REF: Notice of Application, SE-21-00017

I'd like to comment about the subject Proposal and list some questions. As well as clarify a road issue, as shown on exhibit 2, Clear View Concept Plot Map as envisioned by Encompass, May 2006. This plot layout and its Vicinity Map indicate the property is directly accessed from the North via Stoneridge Drive and then Whisper Creek Drive (both are private, asphalt improved roads) and then is bounded on the south by Fowler Creek Road. However at one point Fowler becomes Pasco Road – which does actually border subject land to the south, via an short, steep hill side. Fowler and Pasco Roads are county roads. Pasco and east half of Fowler Road are low use, dirt, unimproved roads.

Addition of names of concerned neighbors; SE-21-00017, Clear View plot

**CLEAR VIEW ACRES SHORT PLAT
KITITAS COUNTY SHORT PLAT NO. 06-XX
PTN. OF THE WEST 1/2 OF SEC. 1, T.19N., R.14E., W.M.
KITITAS COUNTY, WASHINGTON**

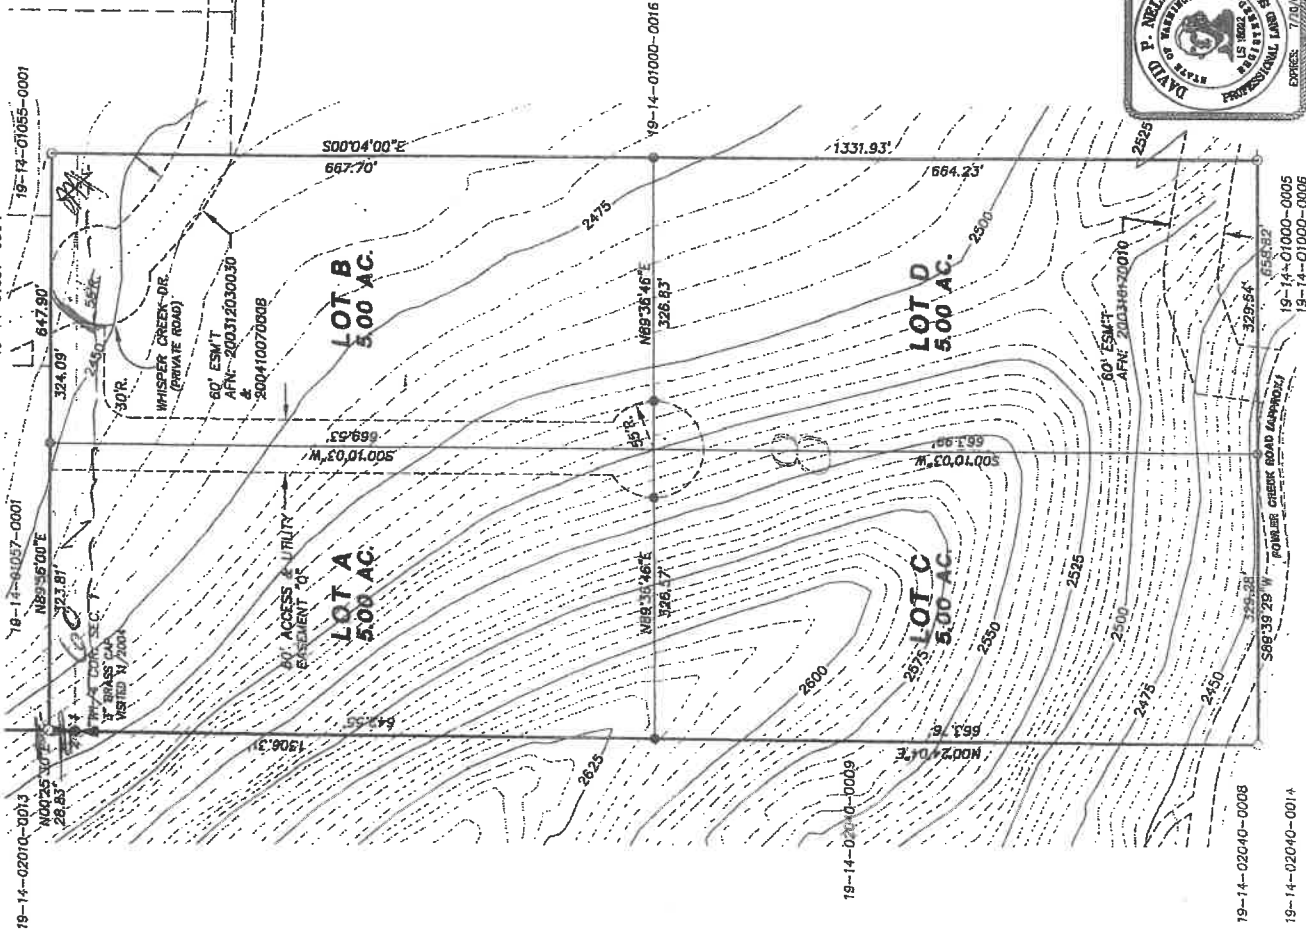
We do have concerns about how the included plot designs showing easements along this property and Pasco Road; for what? Utilities? Why?

They also show a 60' and 3' Easement running along east boundary, north to south. Why? Why such an wide easement? Especially when the provided Plot Map as well as current satellite photos shown a rough access road running north to south, right down the middle of subject property, providing perfect easement to the four proposed five acre lots. This initial rough cut road runs from Whisper Creek Road south over about 5/8th length of this subject property. Perfect ingress/egress and utility access to these four lots. Especially when the home owner accession (HOA) has allowed Blue Span Communications to install Fiber Optic cable along Stone Ridge Drive and Whisper Creek Drive.

My concern is the odd 63' of easement along east lot line. As well as possible impact on Pasco Road. As long as we can be assured of no vehicle ingress/egress from Whisper Creek Road to Pasco Road; there are no majors issue with this application. To a degree, even an utility easement might be agreeable. Any impact to the steep ridge along south boundary and Pasco Road would be of a concern.
